From: Contact Centre (CRM) <contact@ribblevalley.gov.uk>
Sent: 28 July 2022 16:49
To: Planning
Subject: Planning Application Comments - 3/2022/0553 FS-Case-440453460

Planning Application Reference No.: 3/2022/0553

Address of Development: Higher College Farm
Lower Road
PR3 2YY

Comments: I write as Chair of Hothersall Parish Council to add the following specific notes and recommendations to the response already submitted in letter form.

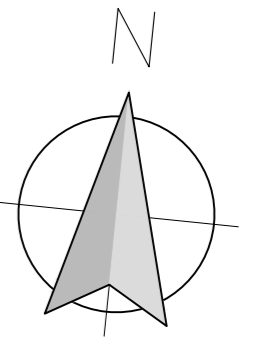
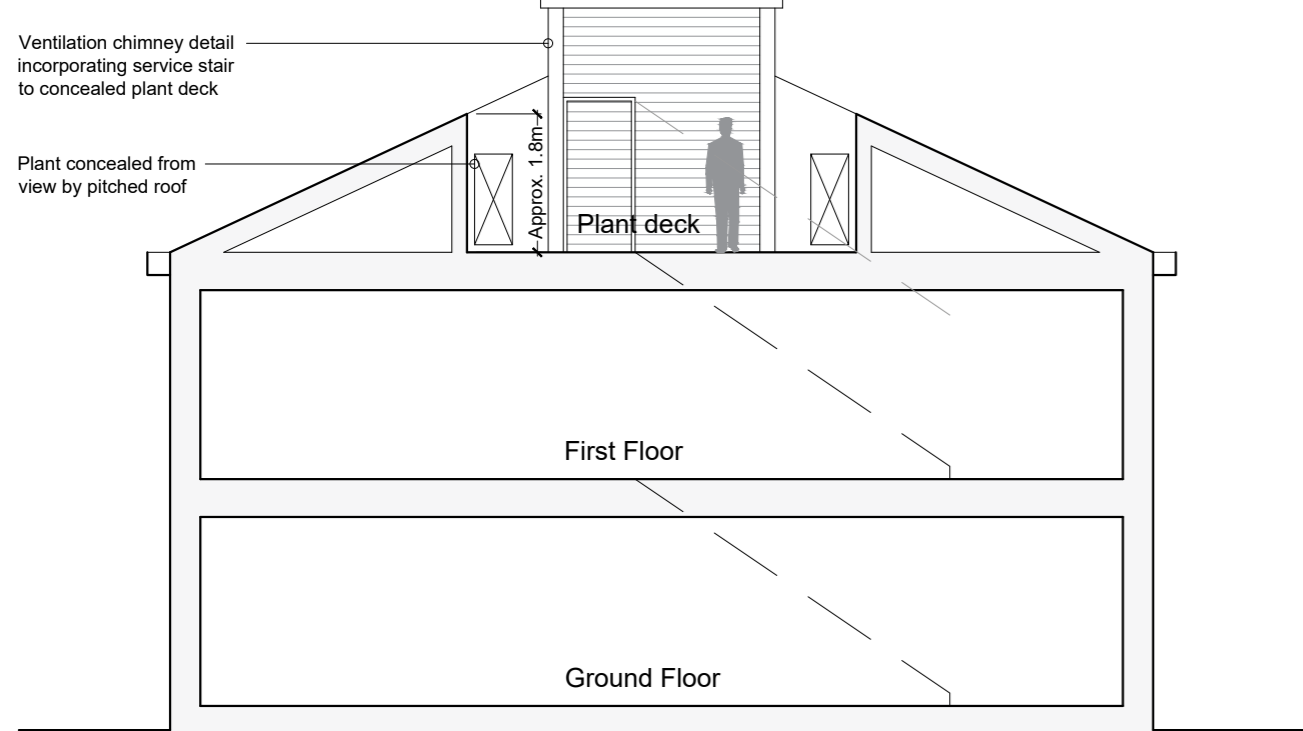
3) While we welcome the choice of stone building materials, we have some concerns about the extent of zinc roofing. We note that when Hillside School built a new centre nearby, a living green roof was used.

Recommendation: to be consistent with the nearby non-domestic building, that zinc roofing be substituted with green roofs such as sedum. This will have the added advantage of slowing water run-off around the site.
